**KIRKLEES METROPOLITAN COUNCIL
INVESTMENT & REGENERATION SERVICE**

DELEGATED DECISION TO DETERMINE PLANNING APPLICATIONS

Reference No: 2019/62/90123/E

Description: Change of use from retail (A1) to hot food takeaway (A5) and new shop front with security shutters and extract flue system (within a Conservation Area)

Sketch

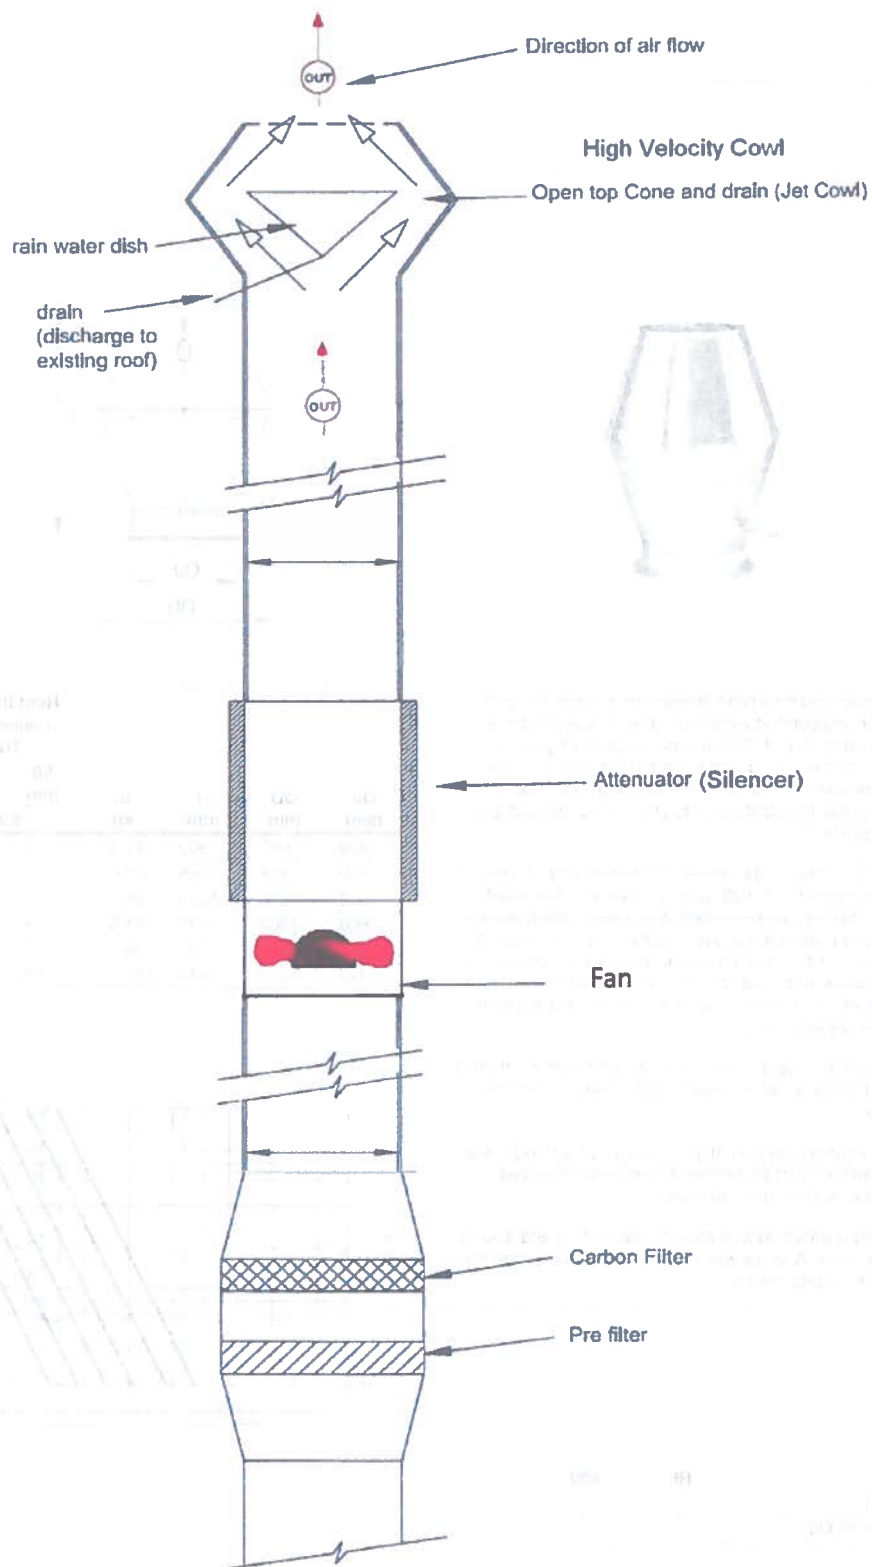
KC Environmental Health – no objections to the development proposal, given a similar application was approved at the site in the past. Two conditions were recommended: the first one relating to the hours of opening and second one to the details of the extract flue system.

4. The use hereby permitted shall not begin until details of the installation and/or erection of any extract ventilation system, including details of the methods of treatments of emissions and filters to remove odours and control noise emissions have been submitted to and approved in writing by the Local Planning Authority and the works specified in the approved scheme have been installed. Such works shall thereafter be retained, operated at all times when the takeaway is in use and maintained in accordance with the manufacturer's instructions.

FRONT 1:100

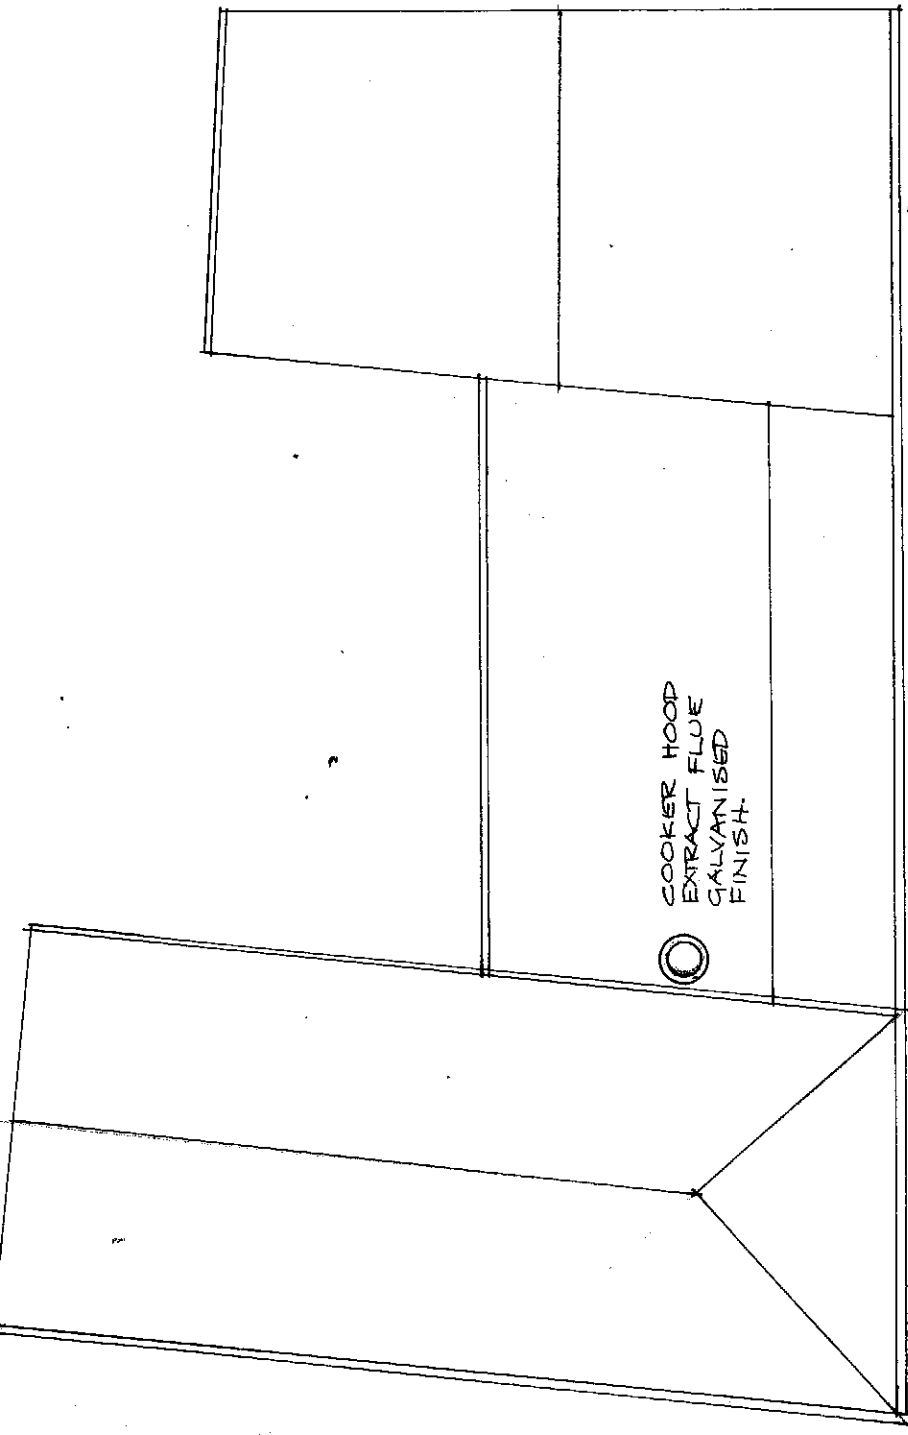
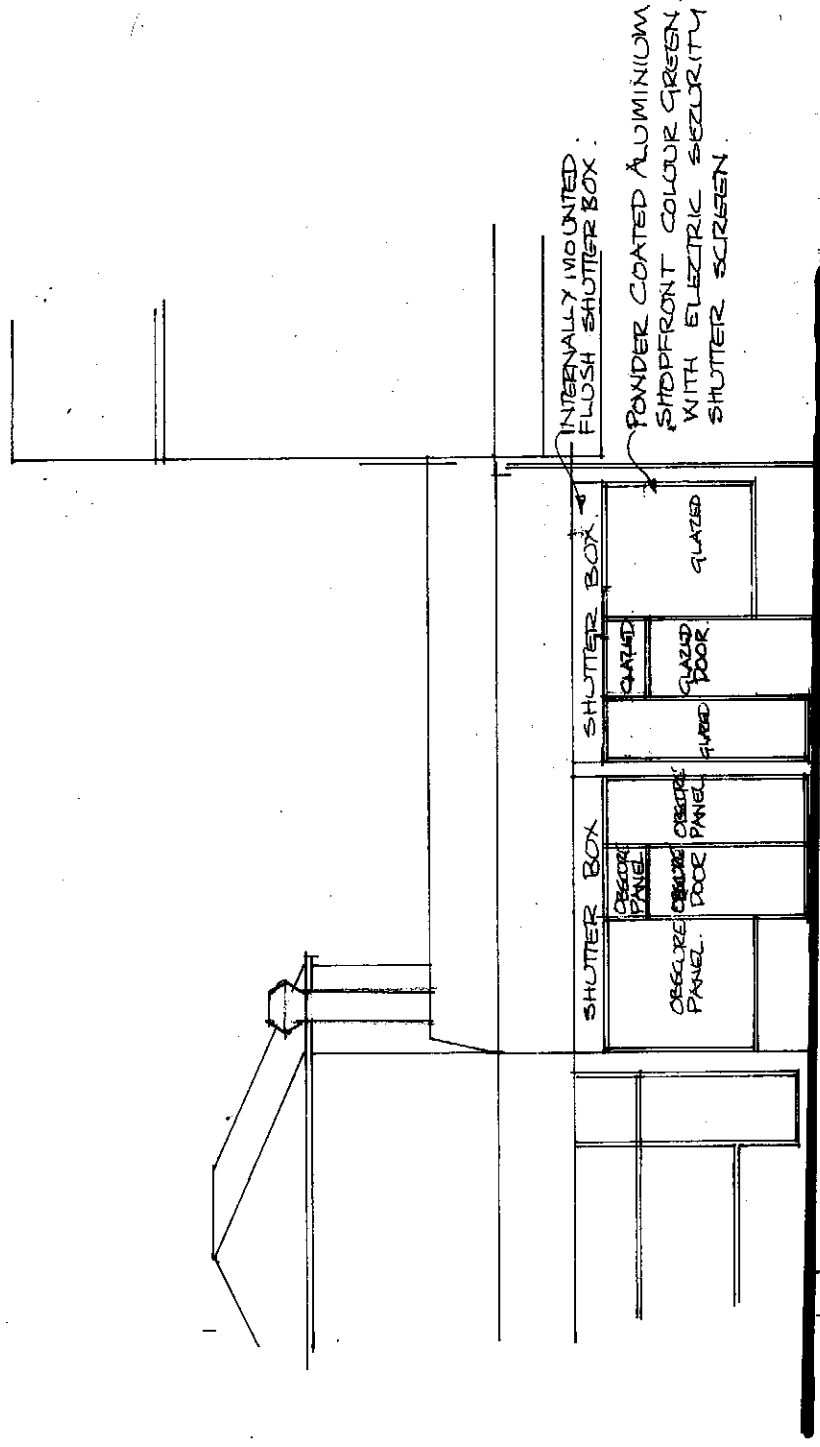
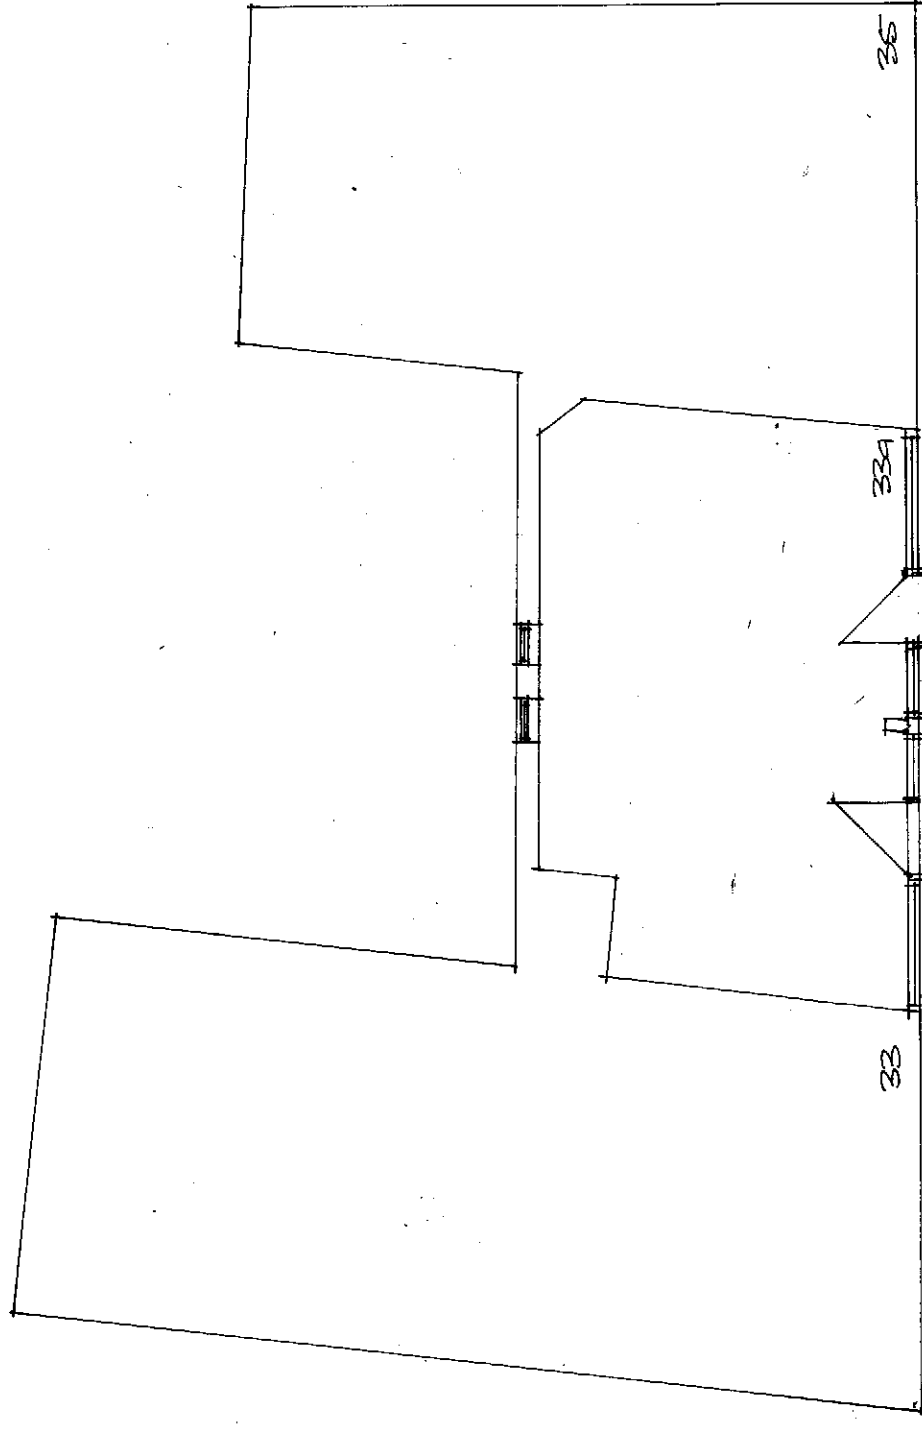
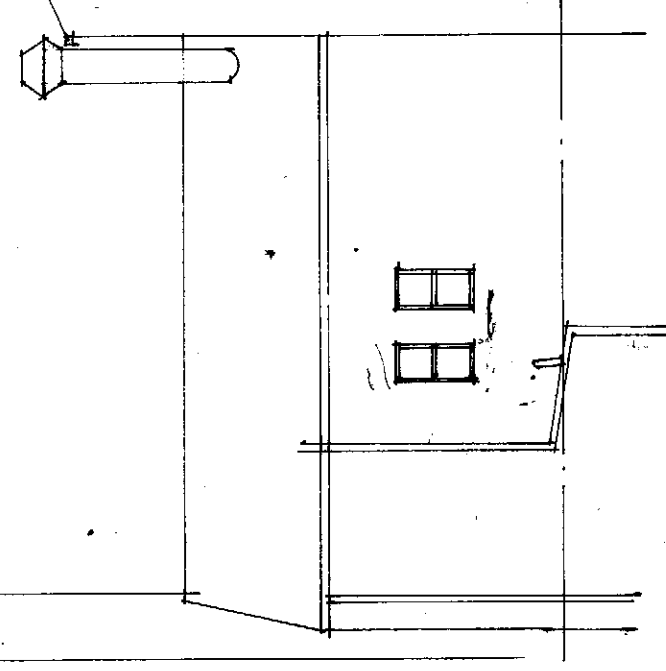
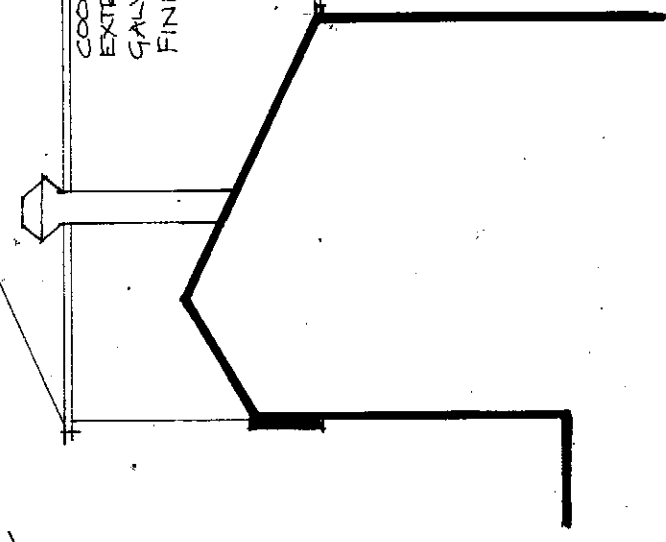
KC Conservation & Design – Some concerns regarding the original design of the proposed shopfront. The Conservation officer recommends that the symmetry of the existing shopfront shall be maintained and that the solid panels should be replaced by obscure glazed panels. The shutter box needs to be installed behind the fascia sign. Subject to the above amendments, the proposal can be accepted from a heritage perspective.

The proposal would involve some minor alterations to the existing shopfront including the replacement of timber framed windows with aluminium framed windows and the installation of shutter boxes. The aluminium shopfront would be powdered coated in green. There would be an extract flue system installed on the roof of the application property as well. The proposed shopfront would be acceptable in visual amenity terms as it would preserve the symmetry the existing shopfront, consistent with the advice of the Council's Conservation & Design officer. The replacement of solid panels with obscure glazed panel would also reduce the impact of the proposed shopfront on the visual amenity and on the Conservation Area as a whole.

The shutter boxes as proposed would be internally mounted. This is identified as an acceptable option in the Dewsbury Design Guide, although the most appropriate option is to install the shutter box behind the window display. Furthermore, it would have a similar appearance as the existing hot food takeaway in the immediate vicinity. Concerning the extract flue system, it would not cause significant changes to the appearance of the application property or the character of the surrounding area. The impact of the proposal on the Dewsbury Town Centre Conservation Area would be negligible because it would be small in scale and in keeping with the existing character of the Conservation Area. That being said, a condition shall be attached to the decision notice to require the shopfront to be finished in olive green. This is to ensure a satisfactory appearance of the proposed shopfront and to avoid harm to the Conservation Area. Subject to the recommended condition, the proposal would accord with policies PLP24 (as modified) and PLP35 (as modified) of the KLP and chapters 12 and 16 of the NPPF.

The development proposal has been amended to address the concern of the Council's Conservation & Design officer. These amendments include the replacement of solid panels with obscure glazed panels as well as the reposition of doors to maintain the symmetrical relationship of the existing shop front. The amended drawing was not re-advertised as the amendments were considered minor in nature. There were no comments received as a result of the initial publicity either. On the basis of the above, it is not deemed necessary to re-advertise the amended proposal in this particular case.

3. The shopfront hereby approved shall have an olive green colour finish [RAL6603] on first installation and thereafter retained.
